# **EL PASO COUNTY PLANNING AND COMMUNITY DEVELOPMENT DEPARTMENT**

## **STORMWATER MANAGEMENT PLAN CHECKLIST**

Revised: July 2019

PCD FILE #:SF-20-032

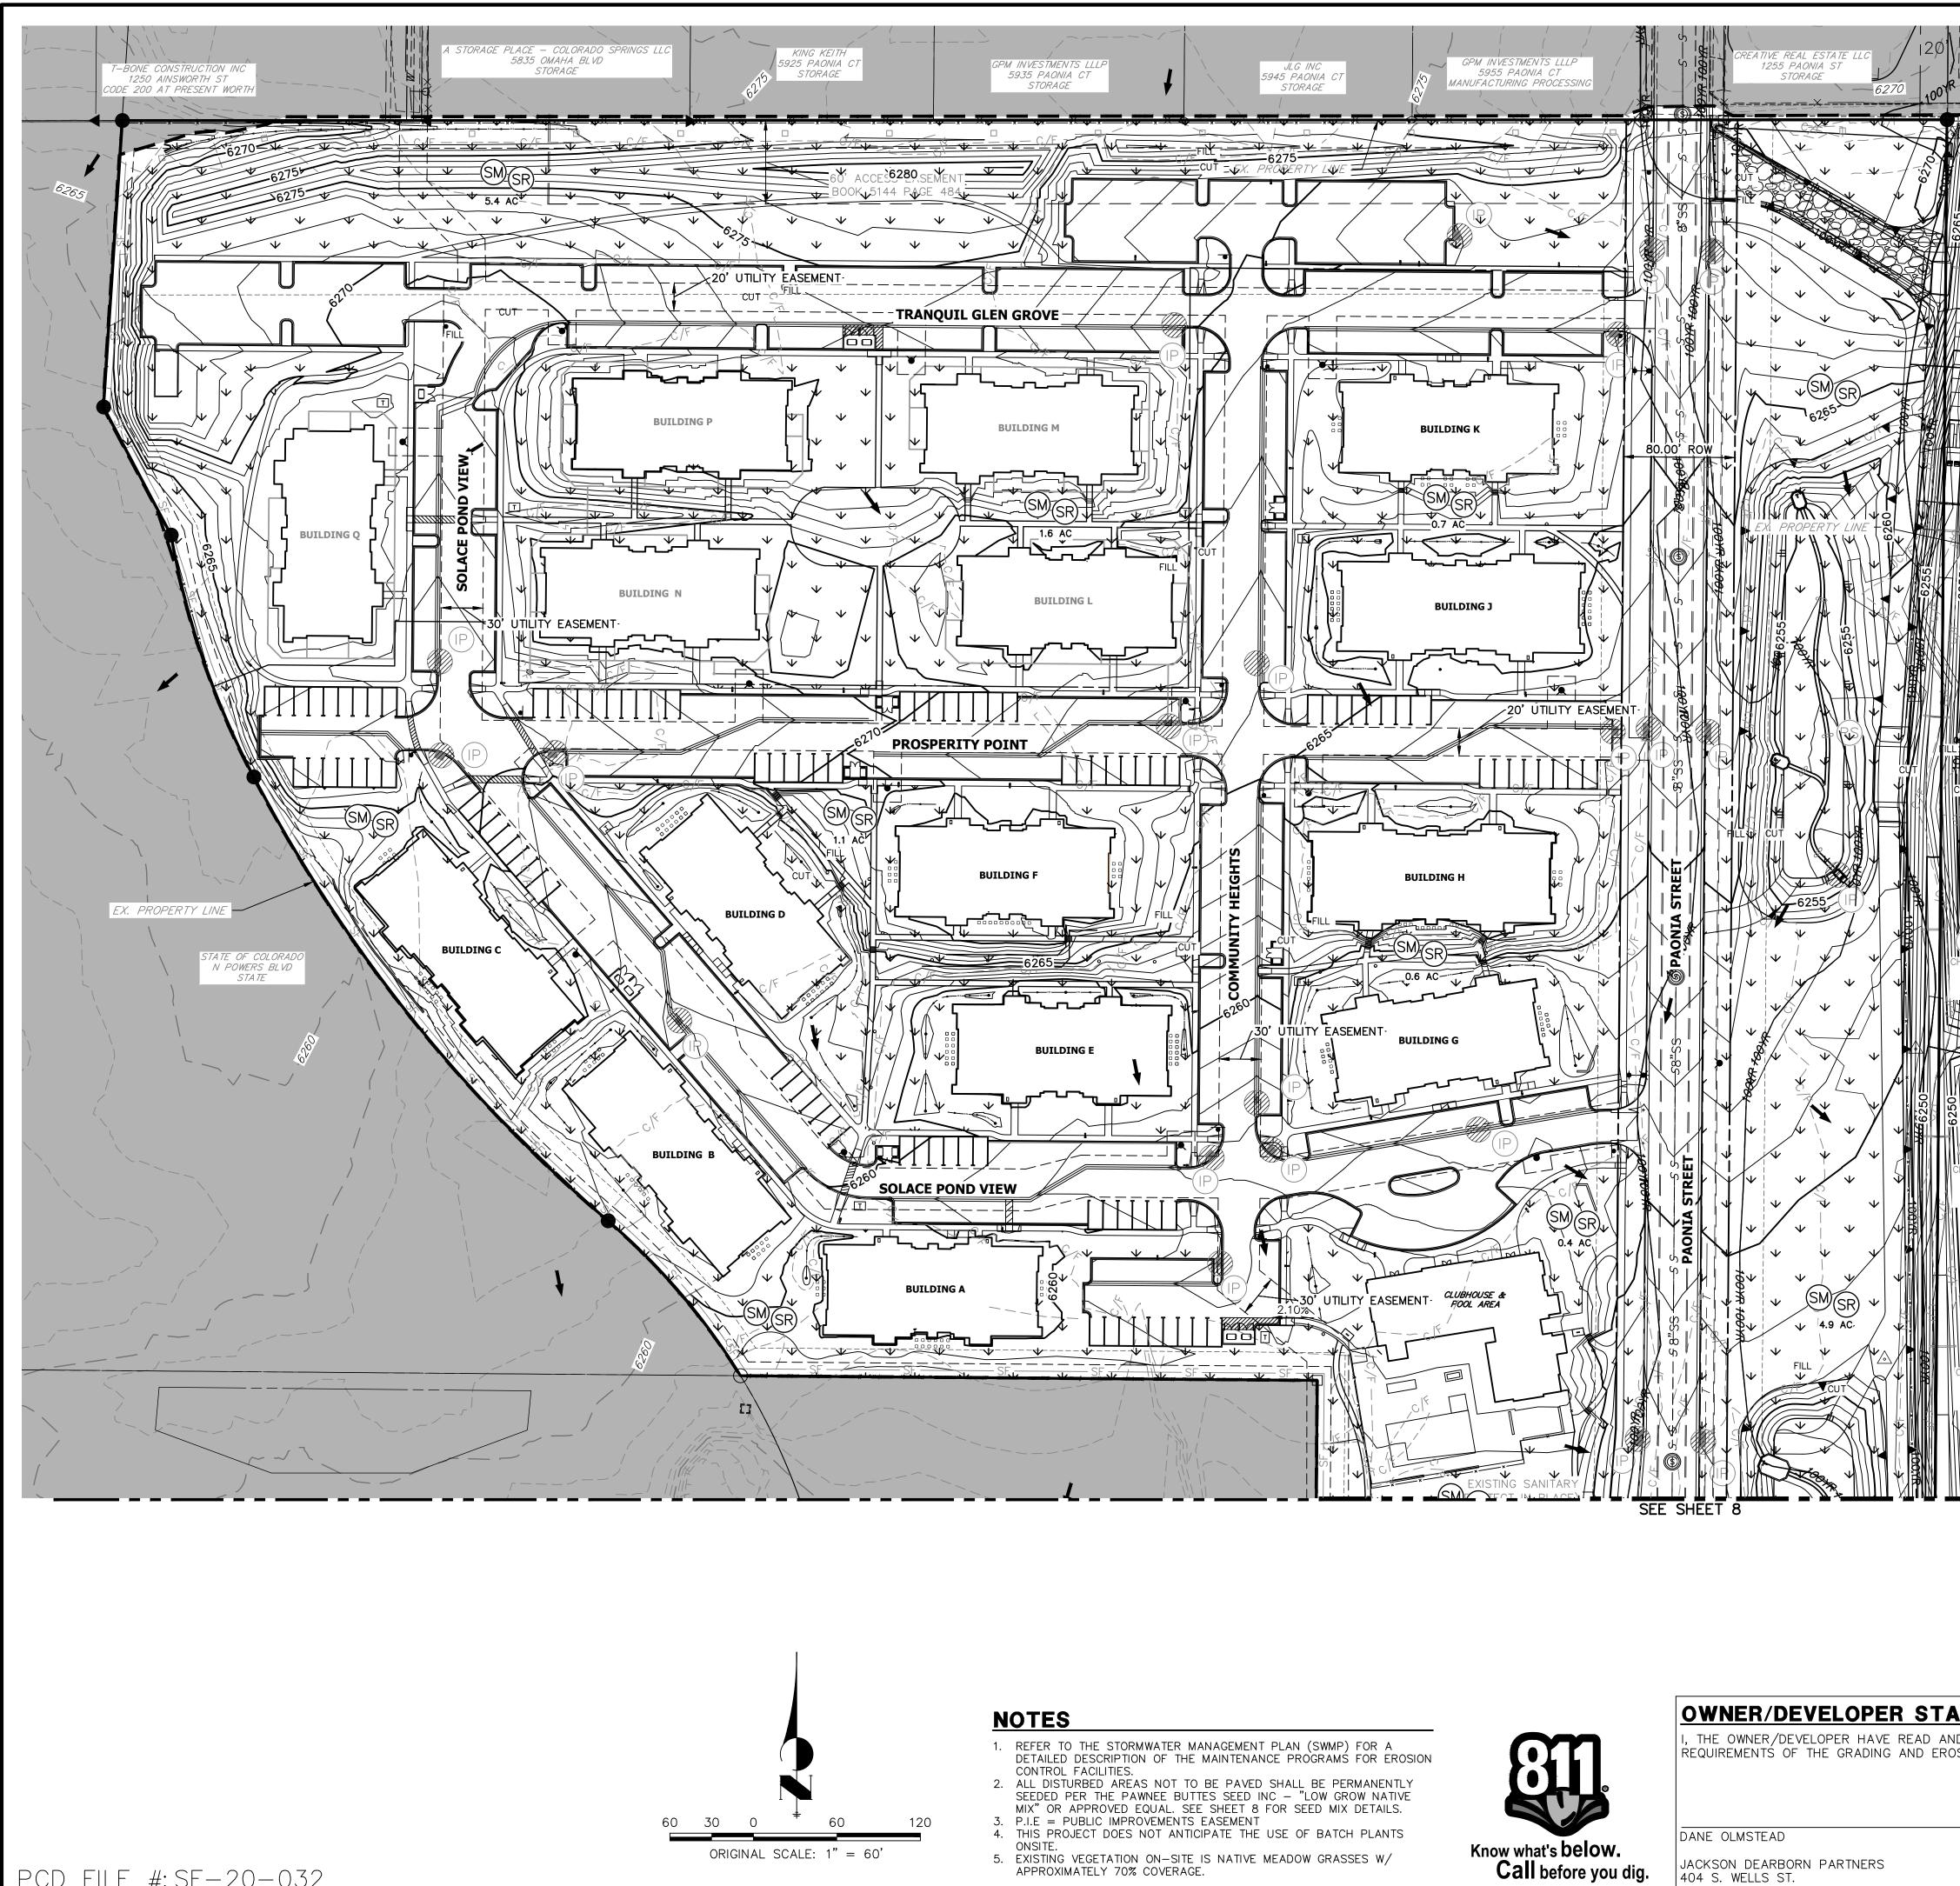
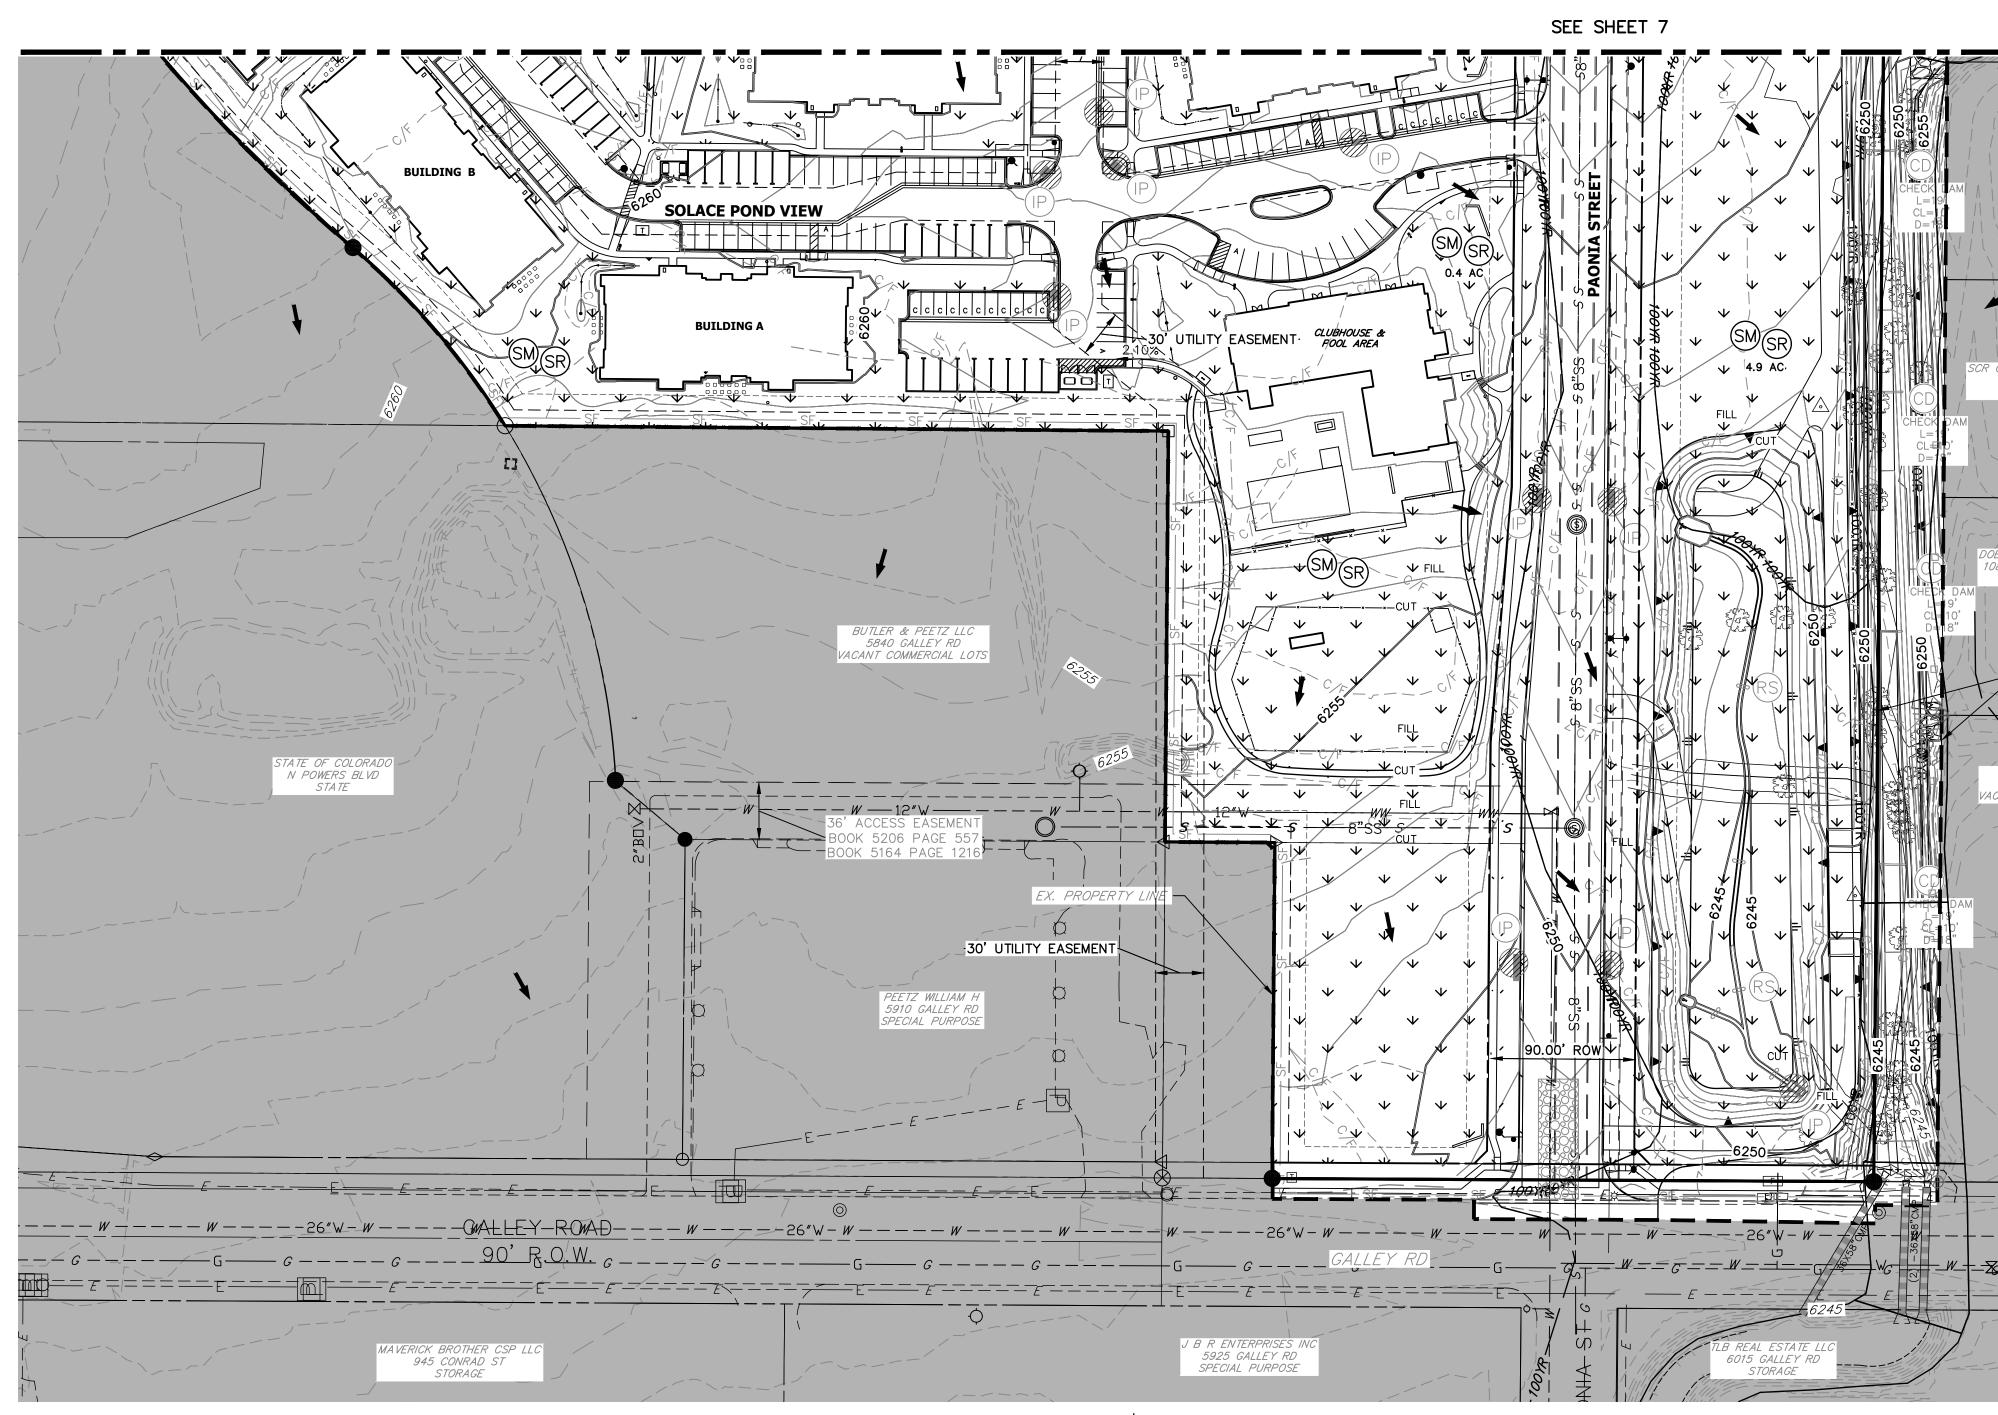
Revised: July 2019		Applicant	PCD
17	SWMP Map to include:	✓	
17a	construction site boundaries	✓	✓
17b	flow arrows to depict stormwater flow directions	✓	X
17c	all areas of disturbance	✓	X
17d	areas of cut and fill	✓	X
17e	areas used for storage of building materials, soils (stockpiles) or wastes	✓	✓
17f	location of any dedicated asphalt / concrete batch plants	✓	X
17g	location of all structural control measures	✓	✓
17h	location of all non-structural control measures	✓	✓
17i	springs, streams, wetlands and other surface waters, including areas that require maintenance of pre-existing vegetation within 50 feet of a receiving water	✓	✓
18	Narrative description of all structural control measures to be used. Modifications to EPC standard control measures must meet or exceed County-approved details.	✓	✓
19	Description of all non-structural control measures to be used including seeding, mulching, protection of existing vegetation, site watering, sod placement, etc.	✓	✓
